WEST SUSSEX COUNTY COUNCIL CONSULTATION

TO:	Arun District Council FAO: Amy Myer
FROM:	WSCC - Highways Authority
DATE:	17 November 2021
LOCATION:	Land adjacent to Church Farm Barn, Horsemere Green Lane, Climping, BN17 5QZ
SUBJECT:	CM/64/21/PL Use of land for Class B8 (Storage) for caravan storage. This application may affect the setting of listed buildings & is in CIL Zone 3 (Zero Rated) as other development.
DATE OF SITE VISIT:	N/A
RECOMMENDATION:	Advice
S106 CONTRIBUTION TOTAL:	N/A

Drawing Title
Site Layout - AS PROPOSED

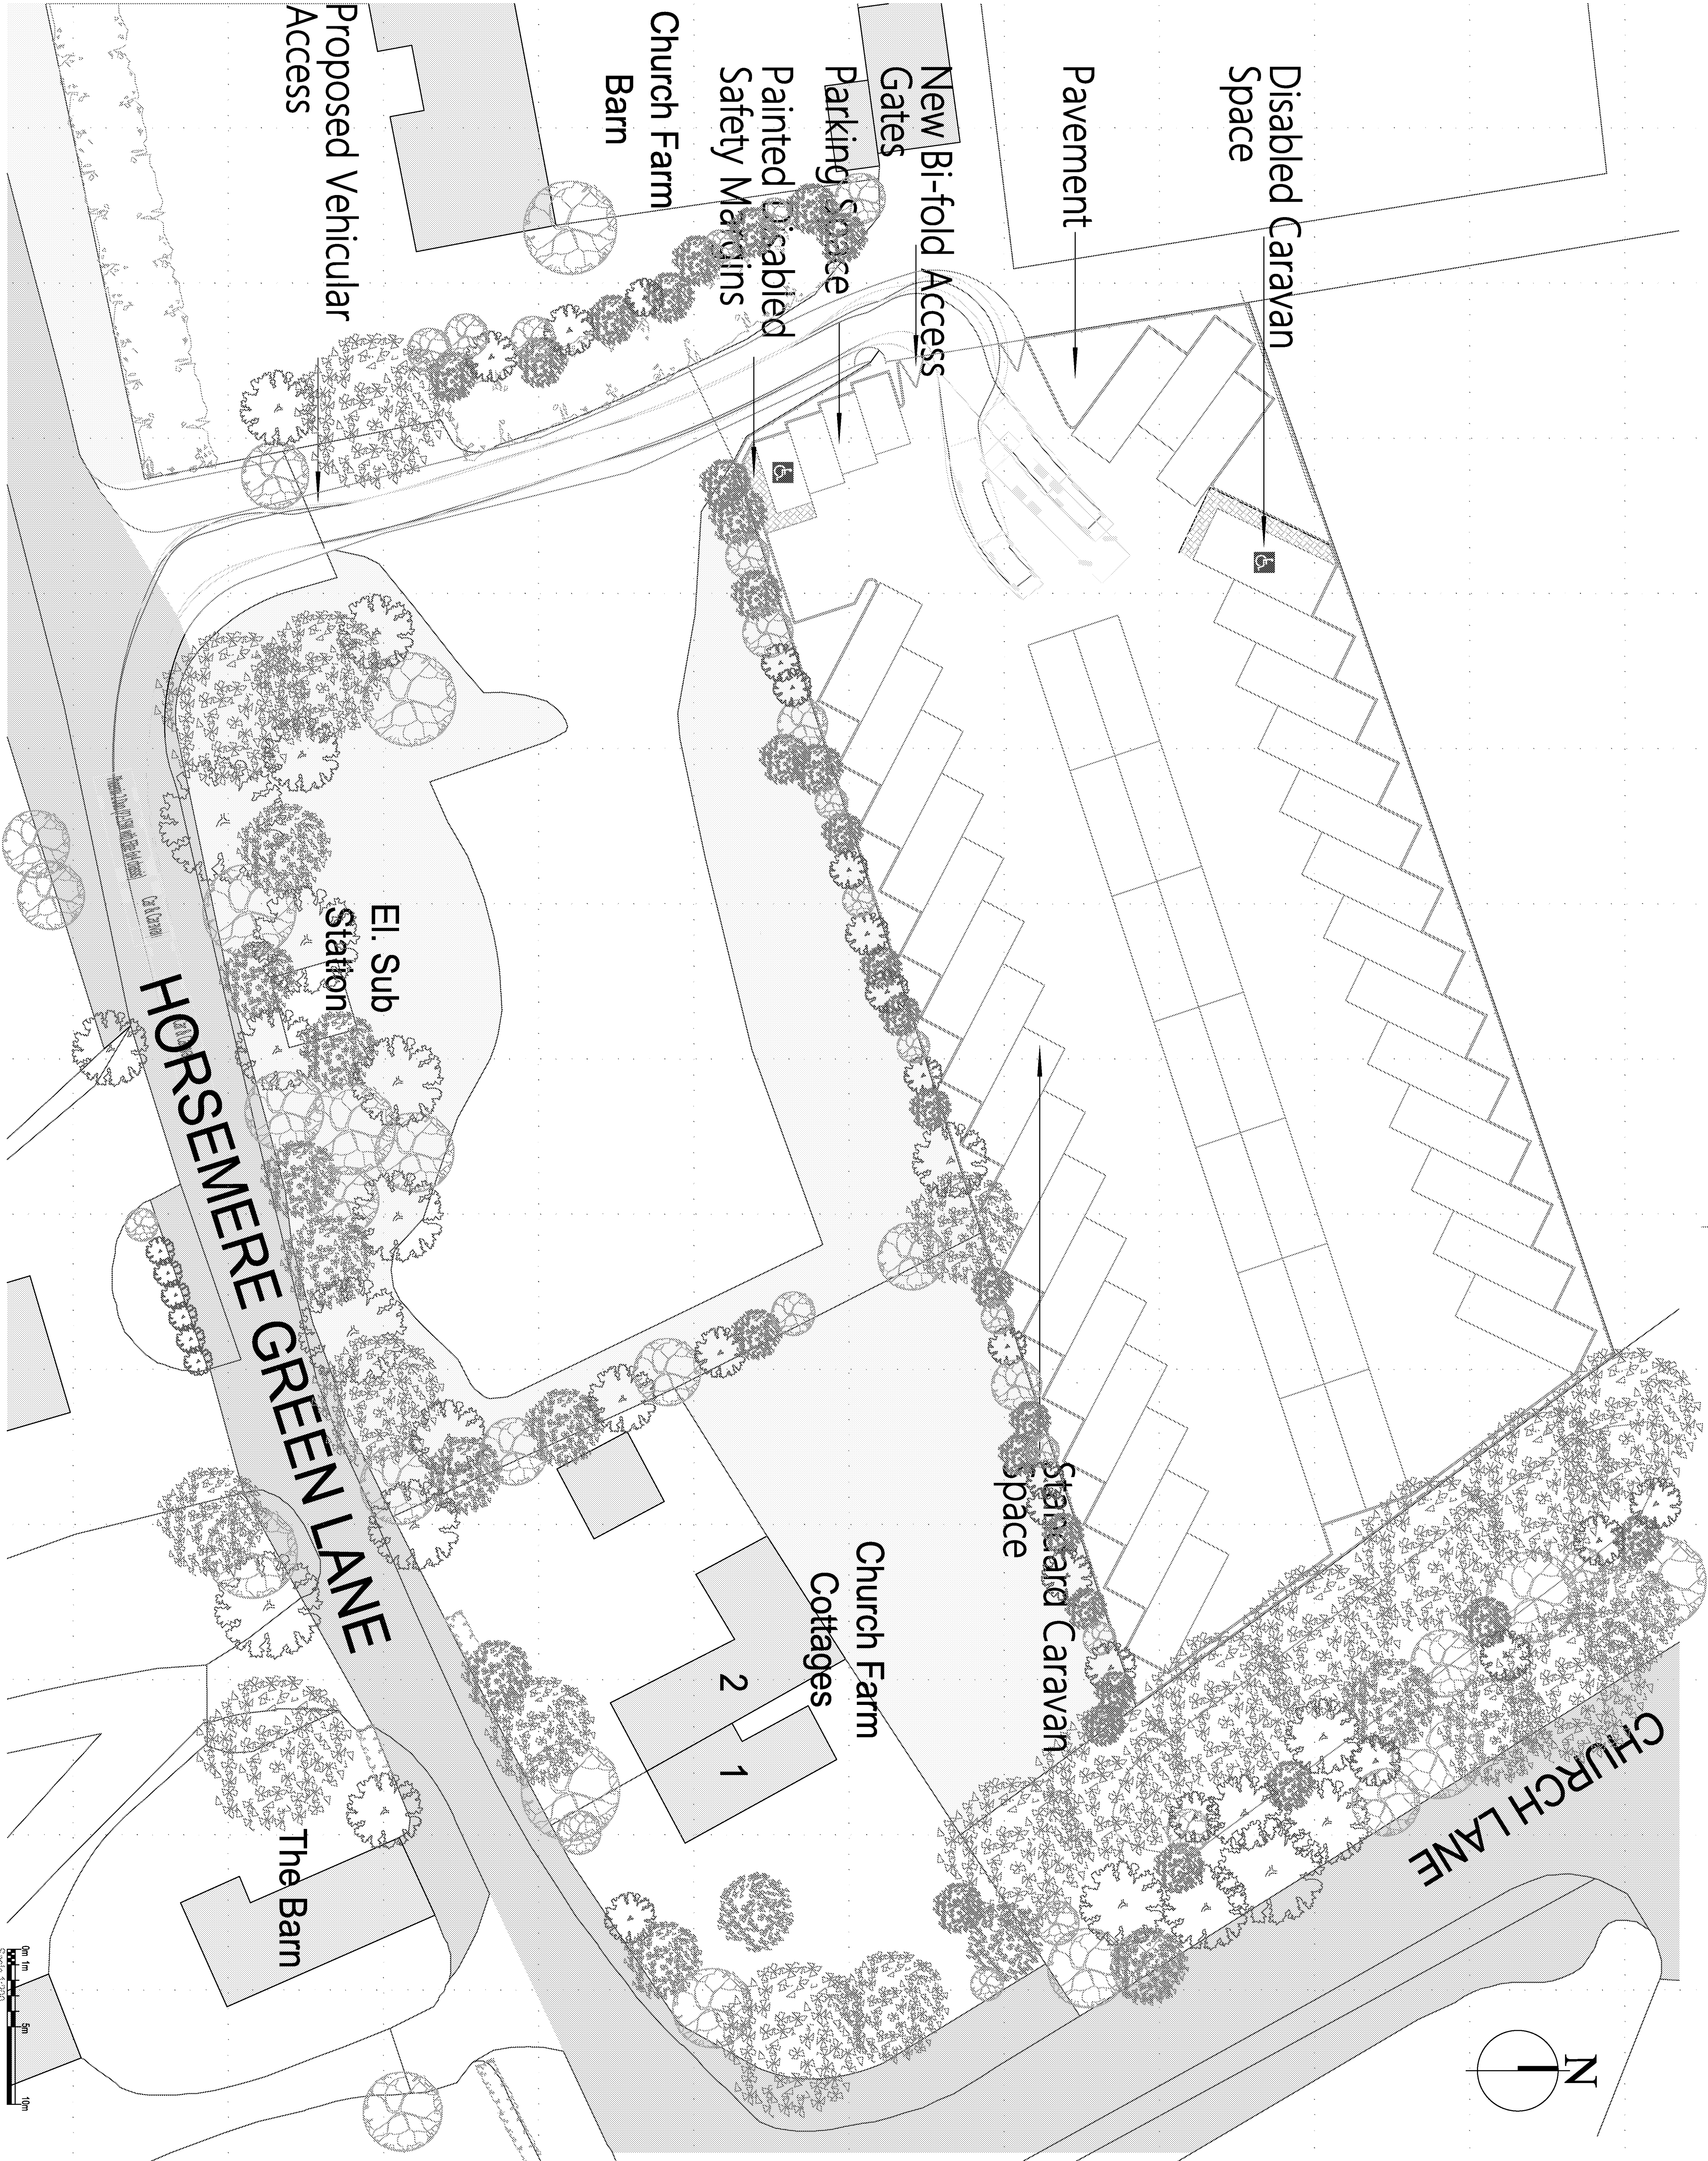
The site will accommodate up to 46 caravans, with provision for four car parking spaces. The LHA anticipates that four car parking spaces will be adequate for a development of this size. From inspection of the plans, the proposed parking bays are suitably sized and on-site turning for a car towing a caravan has been demonstrated via swept path tracking.

No part of the development shall be first occupied until the car parking has been constructed in accordance with the approved site plan. These spaces shall thereafter be retained at all times for their designated purpose.

Access Plan

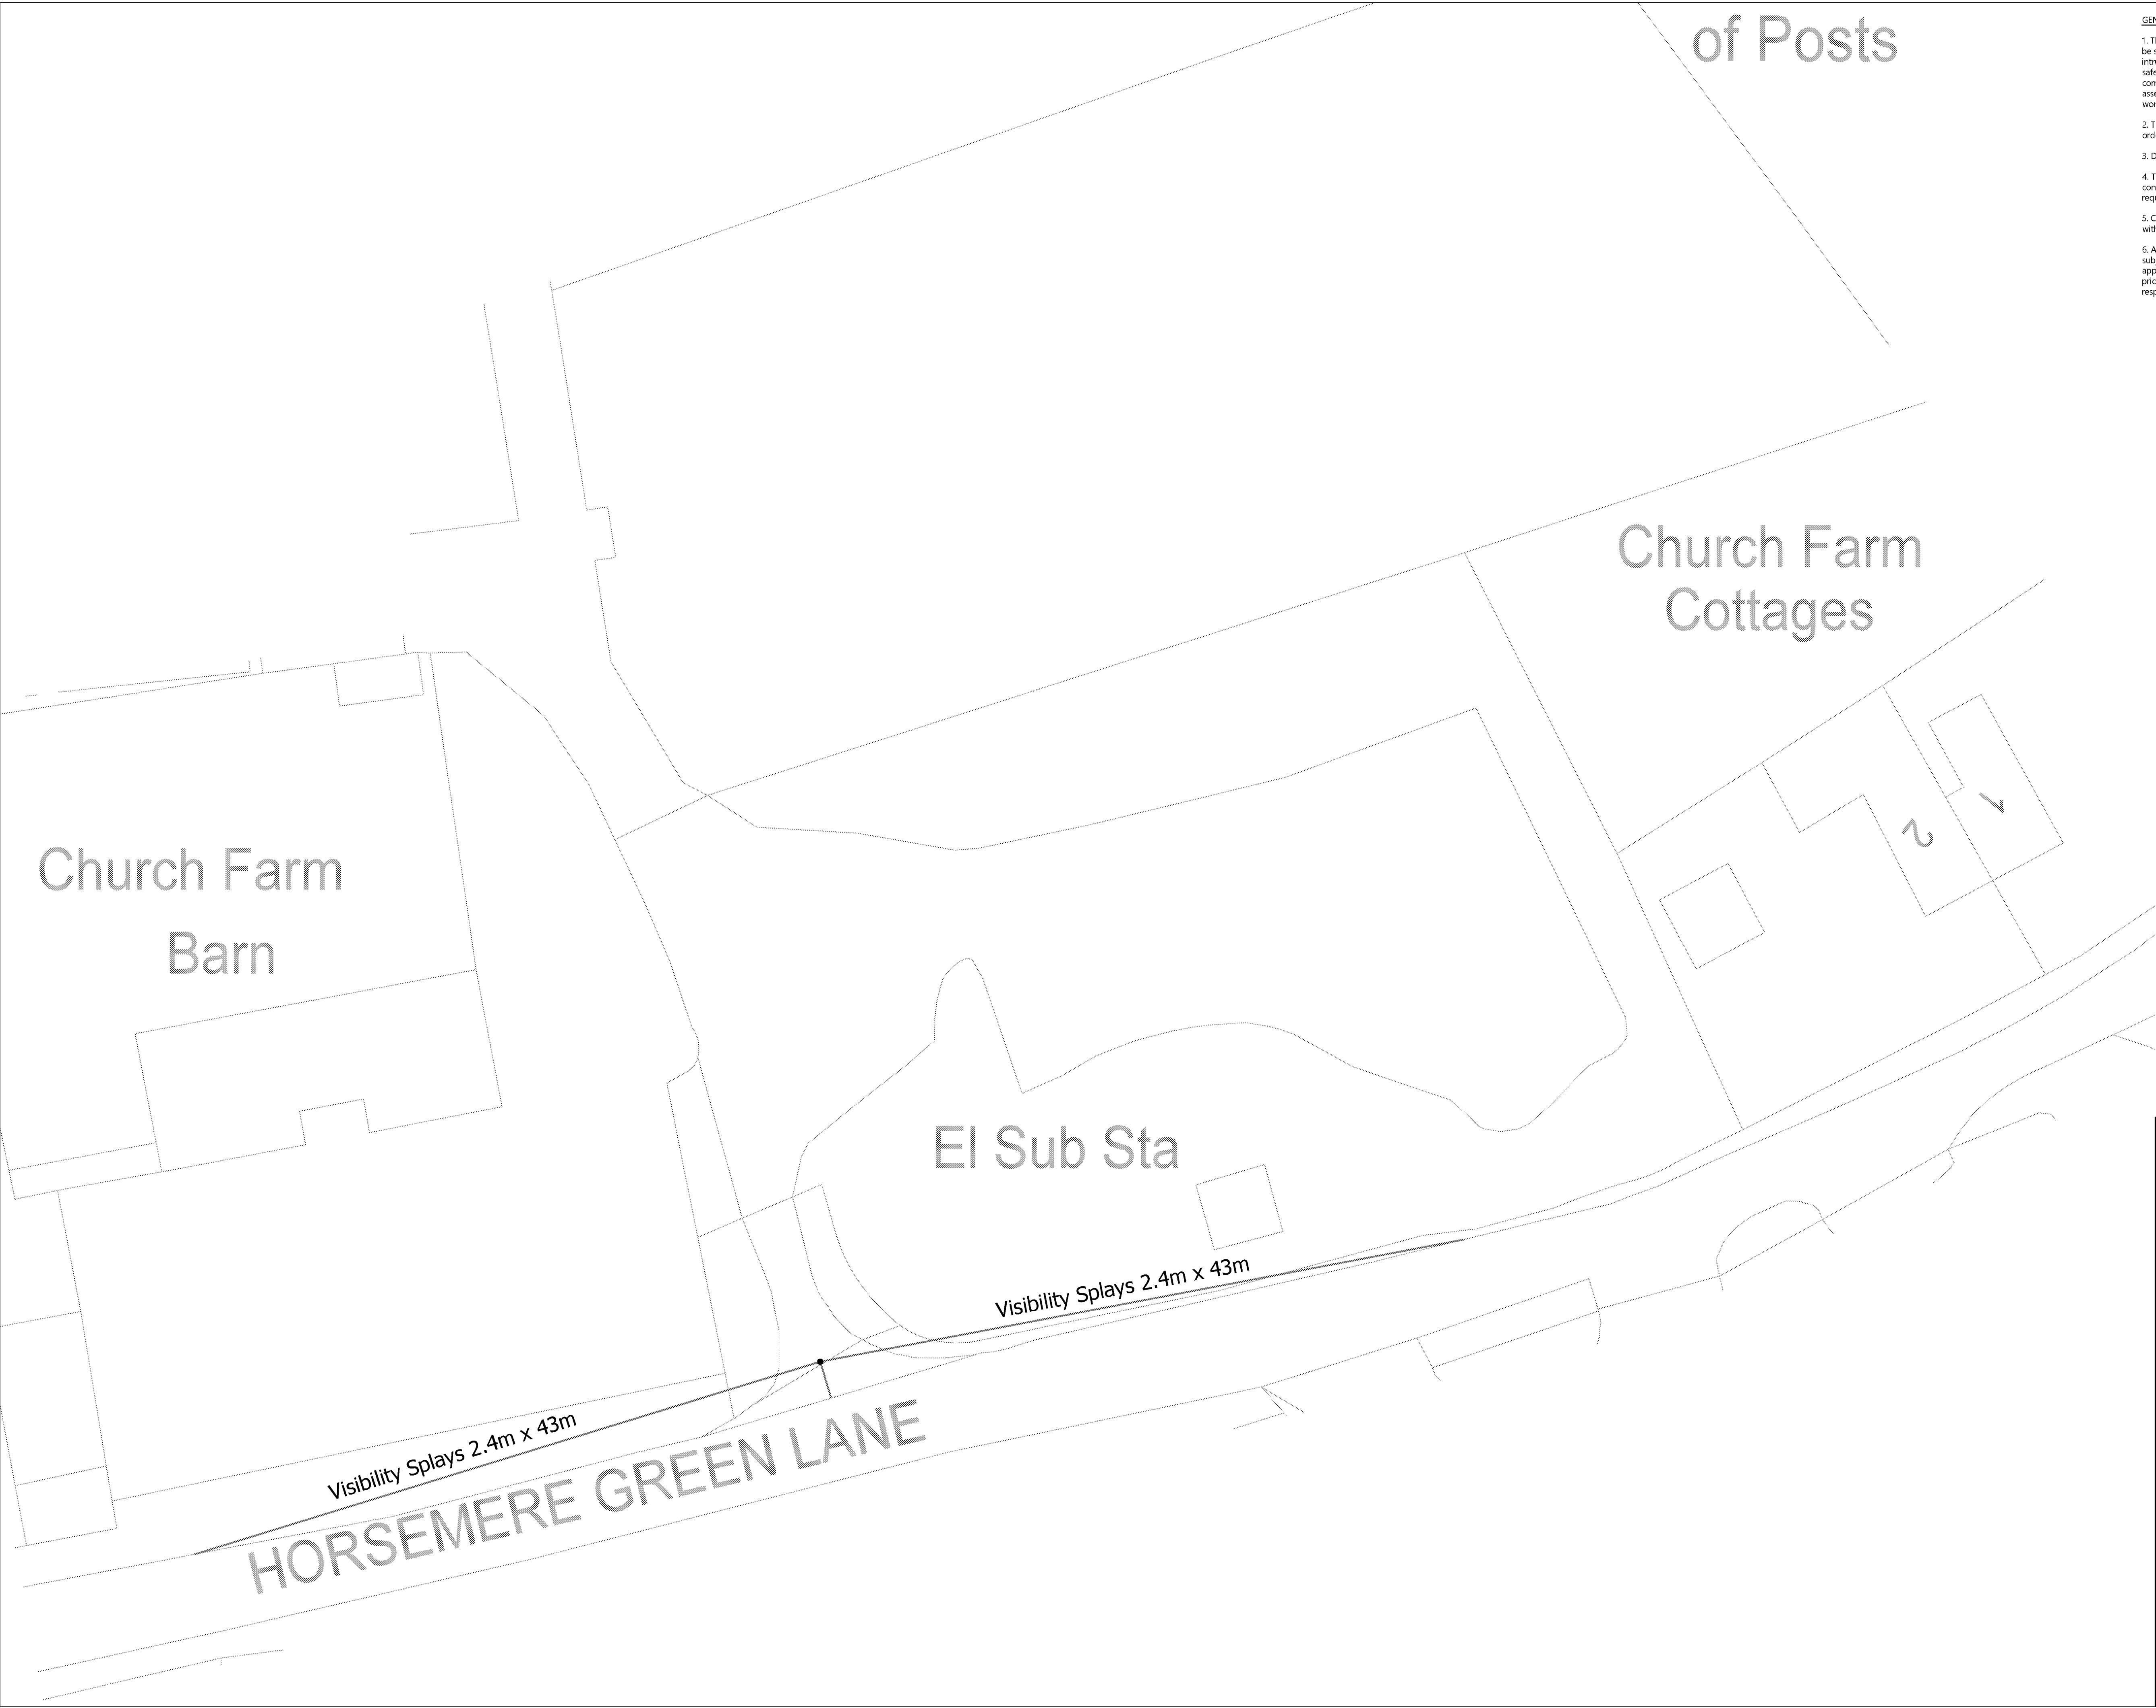
The site will be accessed via the existing vehicular access on Horsemere Green Lane. From inspection of local mapping, there are no apparent visibility issues with the existing point of access on to the maintained highway.
